**Our Case Number: ABP-314724-22**

**Re: Railway (Metrolink - Estuary to Charlemont via Dublin Airport) Order [2022]**  
Metrolink. Estuary through Swords, Dublin Airport, Ballymun, Glasnevin and City Centre to Charlemont, Co. Dublin

# NDA submission for Metrolink Railway order

LEGEND:

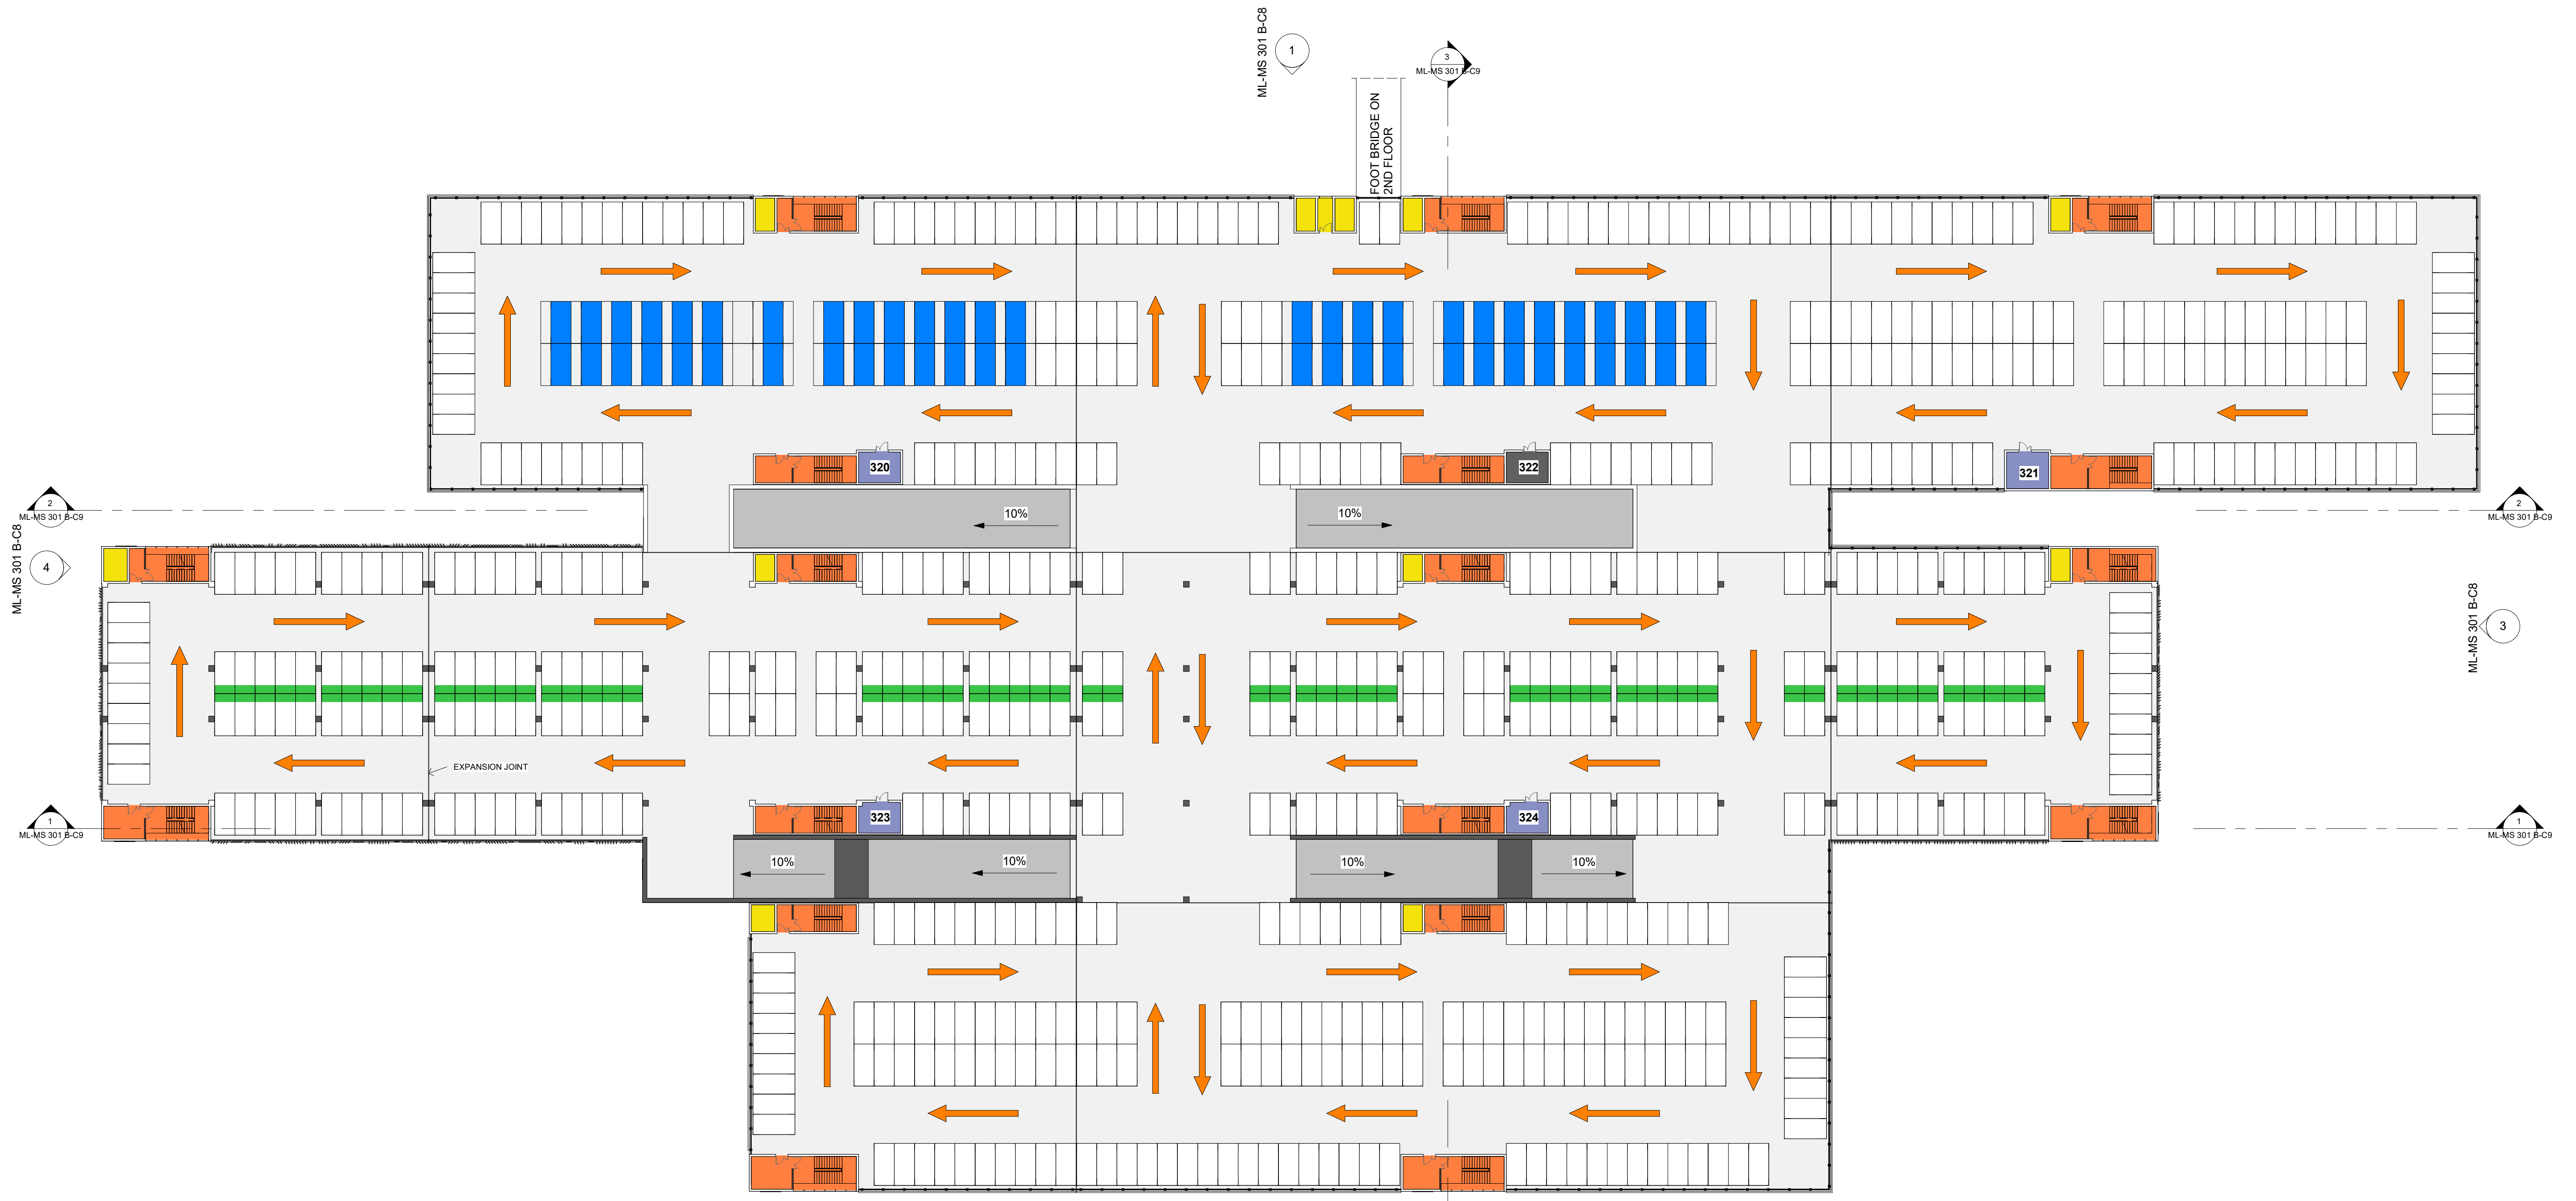
The NDA would also like further detail on how proposed pedestrian underpasses as detailed in the plans for Estuary station and the associated park and ride building will be accessible to wheelchair users for example, as the designs only seem to mention access via stairs and the proposed lifts detailed do not seem to grant access to the underpass level.
